From: Laura Gibbons <Laura.Gibbons@arun.gov.uk>
Sent: 08 December 2020 15:59
To: Planning.Responses <Planning.Responses@arun.gov.uk>
Cc: Maria Tomalova <Maria.Tomalova@arun.gov.uk>; Sarah Burrow <Sarah.Burrow@arun.gov.uk>
Subject: BR/270/20/DOC- 99 Victoria Drive Bognor Regis

Engineers Comments Regarding Condition 5- Surface Water Drainage

Typical Silt Trap Inspection Chamber Detail
(for use in landscaped areas and footways)
Scale 1:20

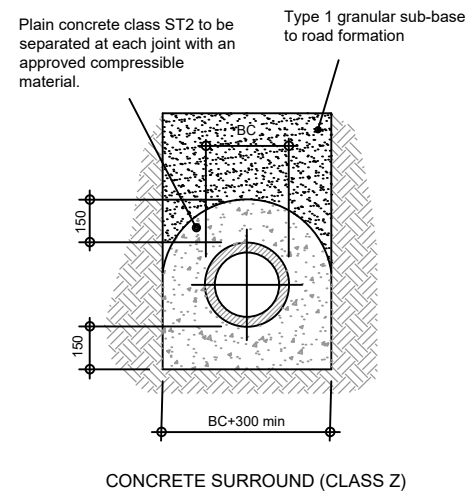
- Please can the applicant update the permeable paving detail to be specific to the site, i.e. to show the minimum required depth.
- Please can it be confirmed/ detailed on the drawings what depth the perforated rings are to extend up to.
- We are unclear on why the ring soakaways extend to the depth they do when this depth does not appear to be required and the invert level will be down far below the peak recorded groundwater level. Please can the applicant provide some commentary on the design.
